From: [REDACTED]
Sent: 11 March 2019 15:36
To: Planning.Responses
Subject: RE: Planning Consultation on: BE/30/19/PL

App No: BE/30/19/PL

Address: Babsham Business Centre Babsham Lane Bersted PO21 5EL

Proposal: Retention of secure containers, welfare facilities & secure fencing together with associated landscaping works.

Photograph 7: Scattered broadleaved tree with moderate suitability for bat roosting (Target note 9 in Figure 3.2).

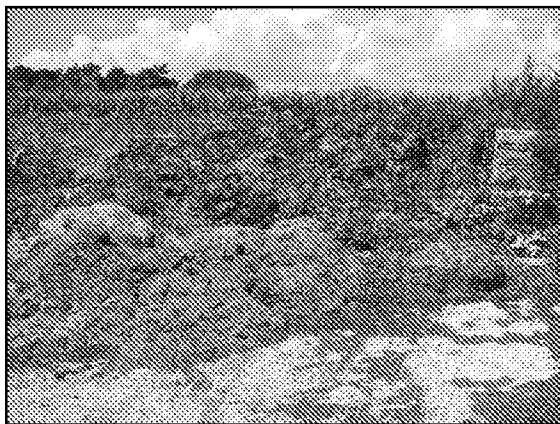
The tree (target note 9) which has been identified as having bat roosting potential on the site will need to be retained and protected from disturbance. If plans change and any works are required to this tree then further surveys for bats will be required.
